February 13, 2018

Response to Geotechnical Review Comments

Re: **351 Croydon, Avenue.**

DRAWING
 TREE CONSERVATION REPORT &
 LANDSCAPE PLAN

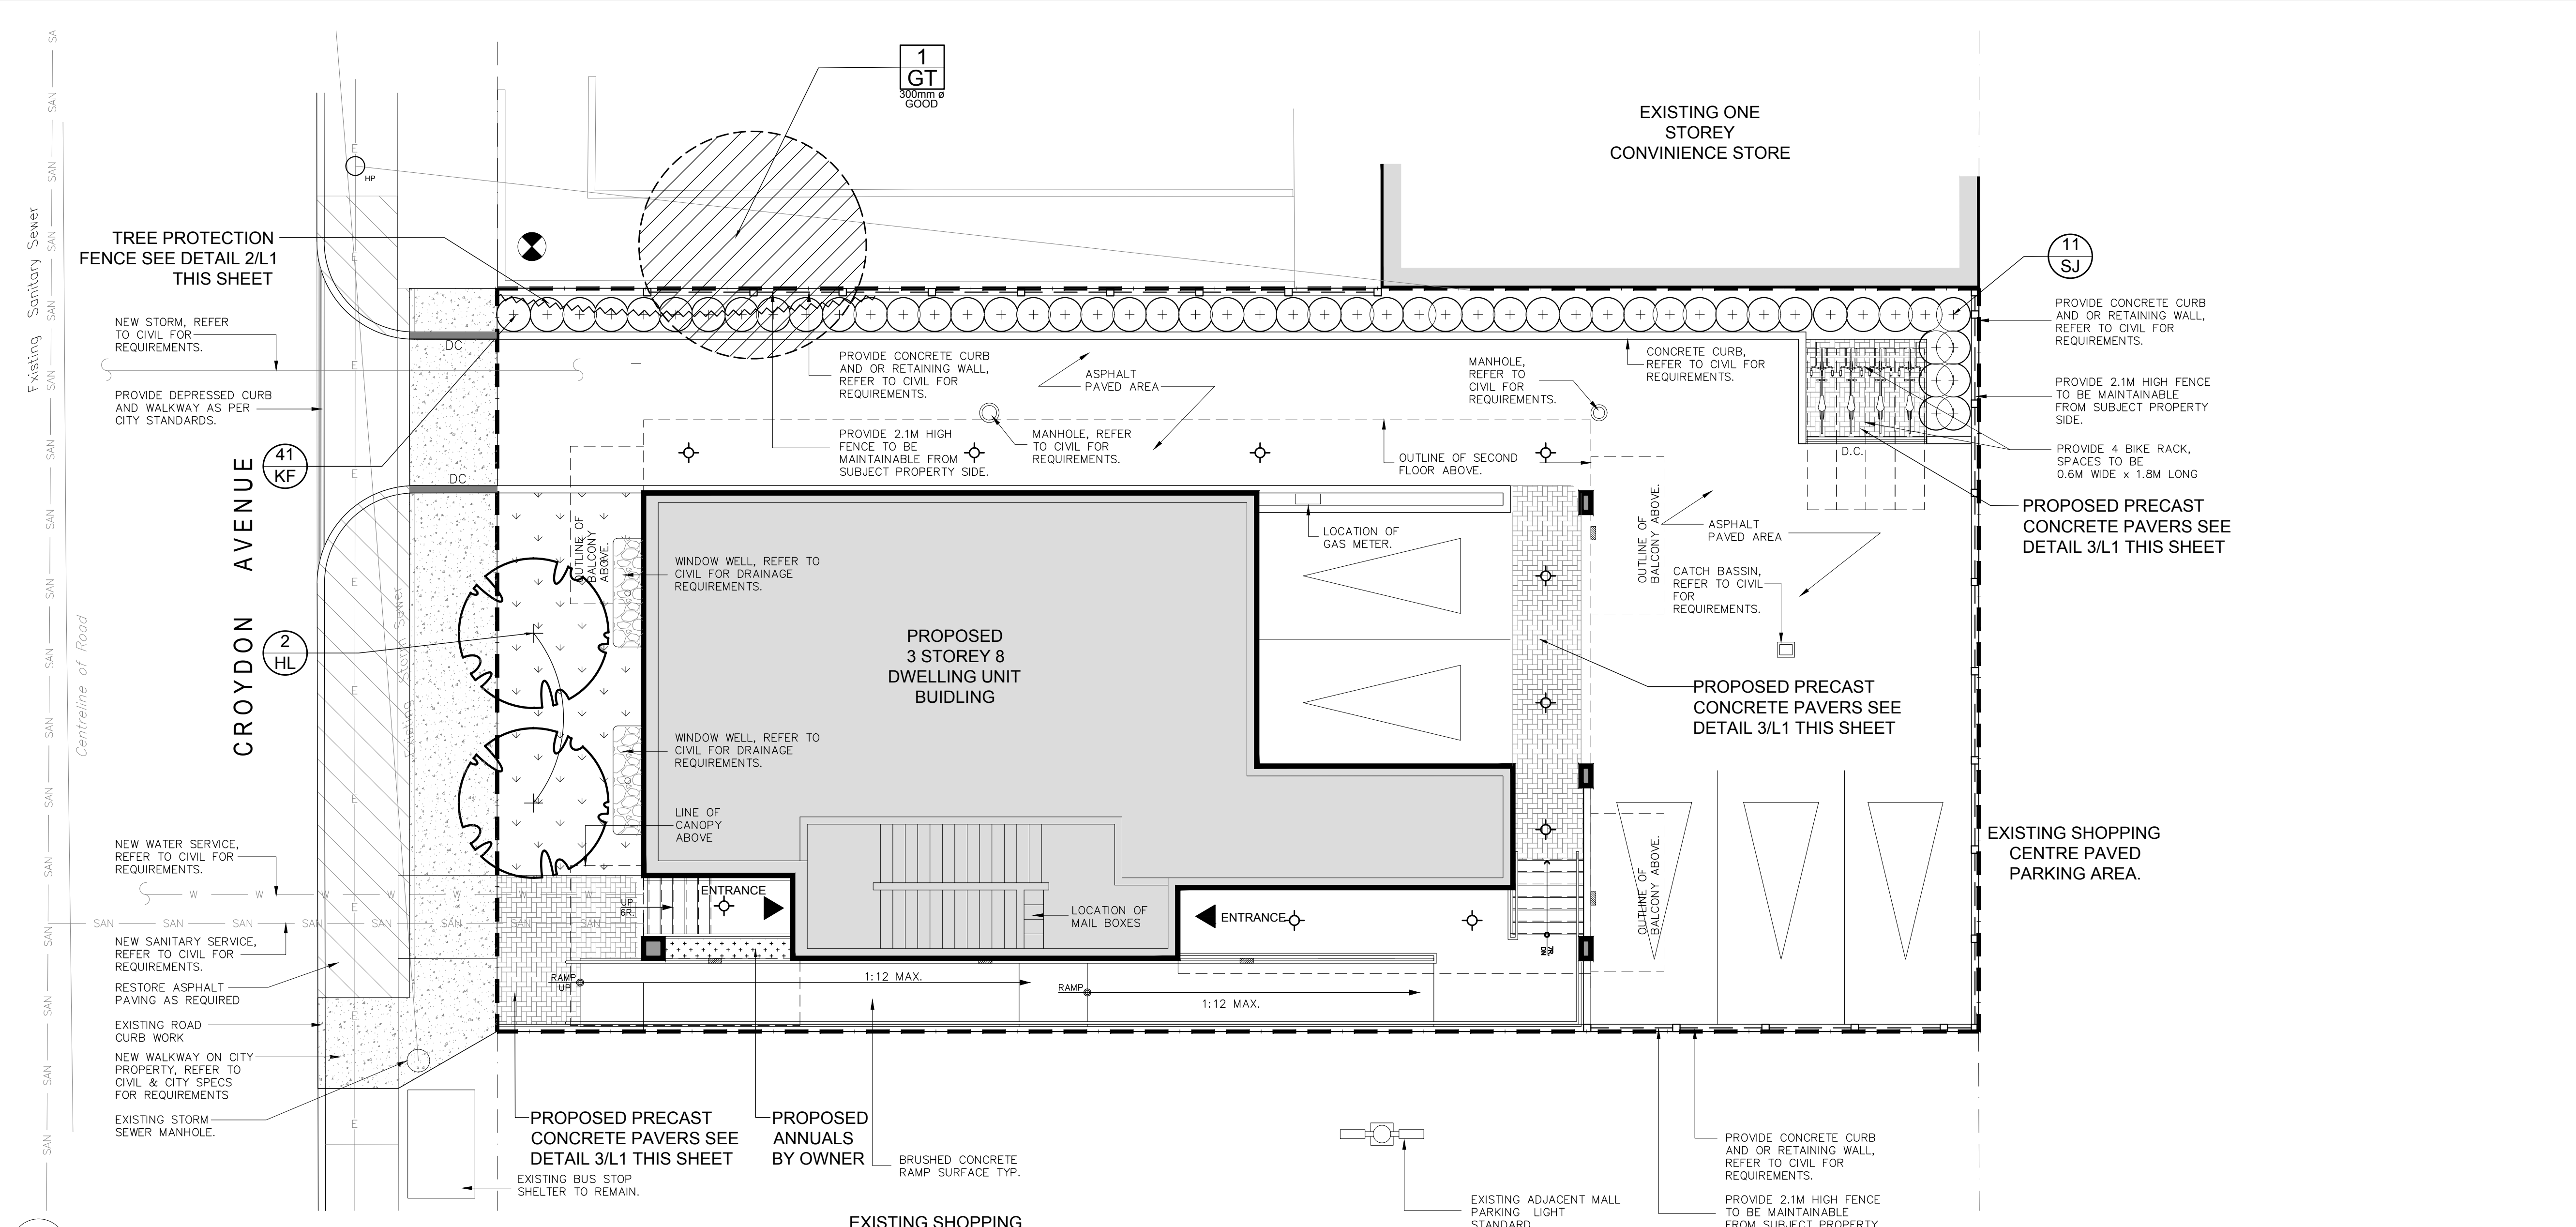
2. Are there any Tree Planting Restrictions applicable for the subject site as trees are being proposed at the front of the property?

The subsurface soils at the site consisted of fill materials overlying glacial till followed by bedrock. The glacial till materials are compact to dense and have a clay content of less than 20%. Compact to dense Glacial Till materials with a low clay content are generally not considered to be vulnerable to shrinkage due to moisture depletion. In order to ensure that the proposed tree planting do not have a negative potential impact on the proposed building, any tree plantings should consist of trees with low water demand.
